Recommendation Report for Planning Permission for Works or Extension to a Dwelling

REF NO: BN/16/21/HH

LOCATION: 8 Collins Close
Chichester
PO20 3JT

PROPOSAL: Single storey detached garage to the front of the property.

Mr. & Mrs. Turner
8 Collins Close, Eastergate, Chichester
West Sussex PO20 3JT
NEW GARAGE PROPOSED ELEVATIONS
Date: FEB 2021 Scale 1:100 Dw no. PR.EL. 01

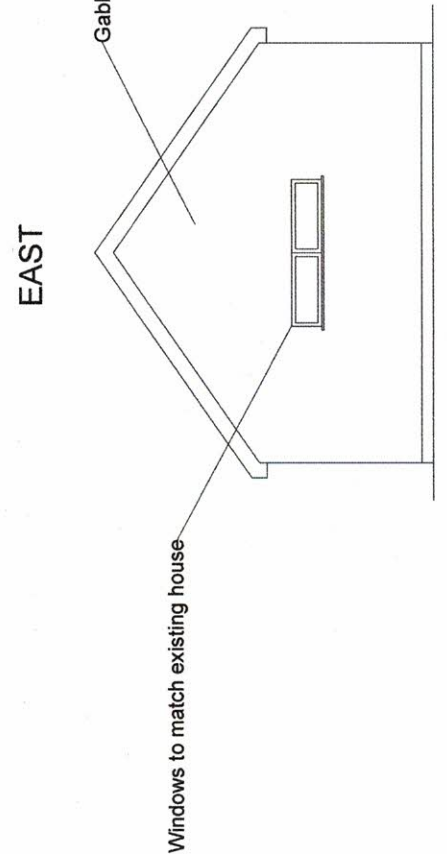
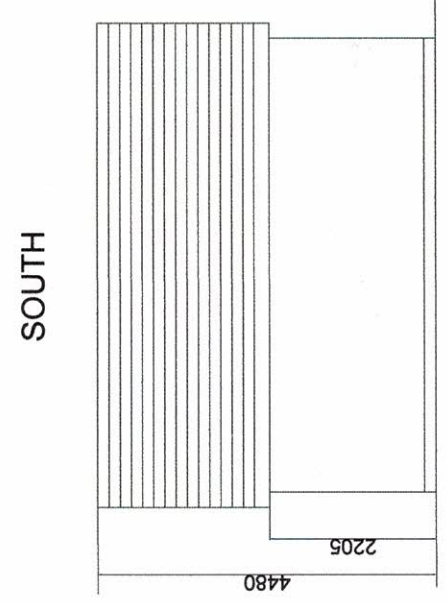
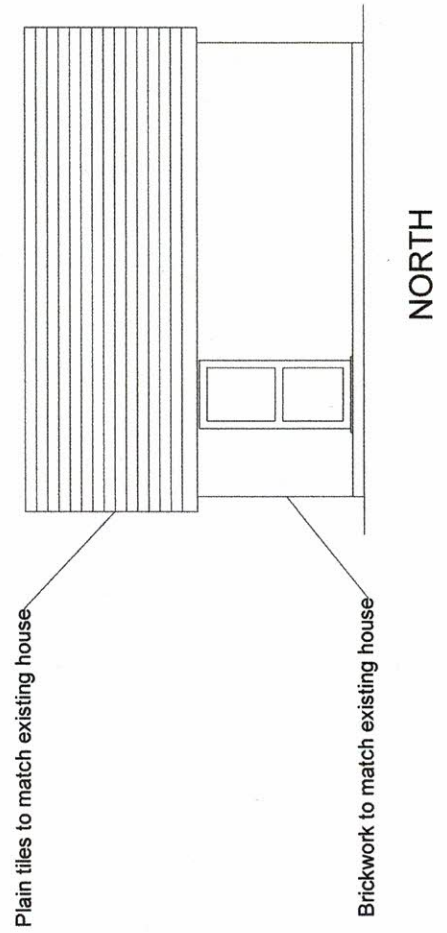
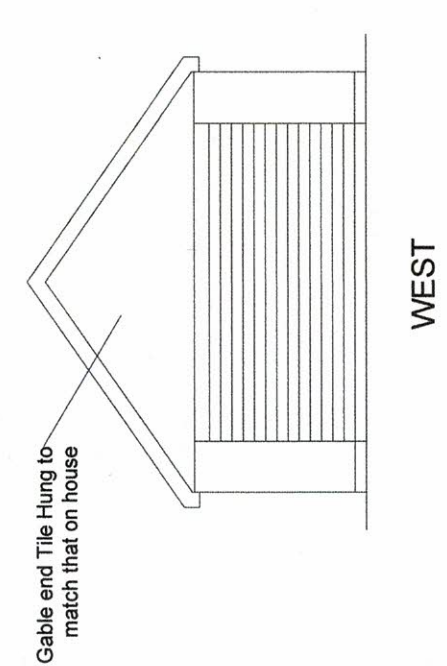
The character of the locality is mixed as a result of the variety of dwelling styles, siting and scales along Collins Close. The garage is sited in the front garden of the dwelling and will be the first of its kind along the east side of Collins Close. To the South side of the road there is one example of visible built form, which is a double garage. The garage is appears sympathetic to the character of the dwelling, and the area.

Mr. & Mrs. Turner
8 Collins Close, Eastergate, Chichester
West Sussex PO20 3JT
NEW GARAGE PROPOSED SITE
Date: FEB 2021 Scale 1:200 Dw no. PR.S. 01

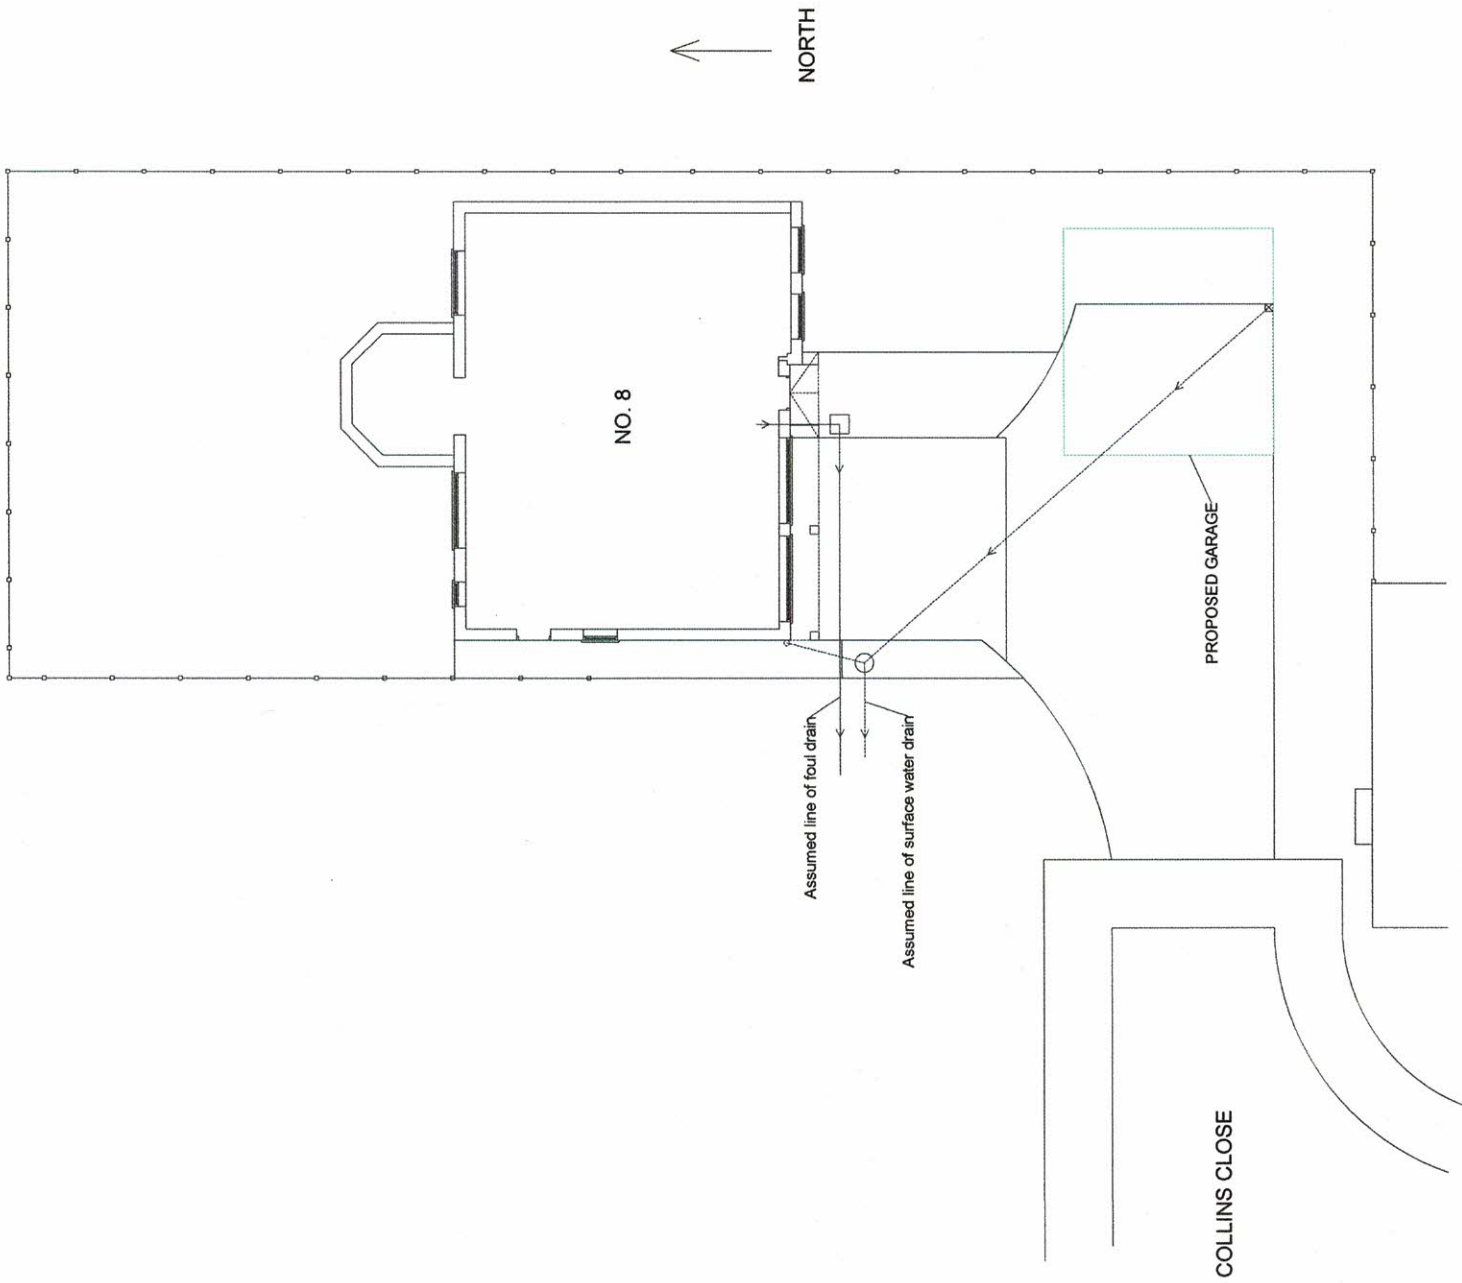
The garage is not considered to result in any unacceptable harmful overbearing or overshadowing impact upon the occupiers of nearby dwellings. This is as a result of the siting of the garage 2.5m from the closest neighbouring dwelling with proposed fruit trees to screen the garage. With regard to potential for loss of privacy to nearby occupiers, the single storey nature of the proposal is considered to ensure that any views from the garage are no different from the application site at current.
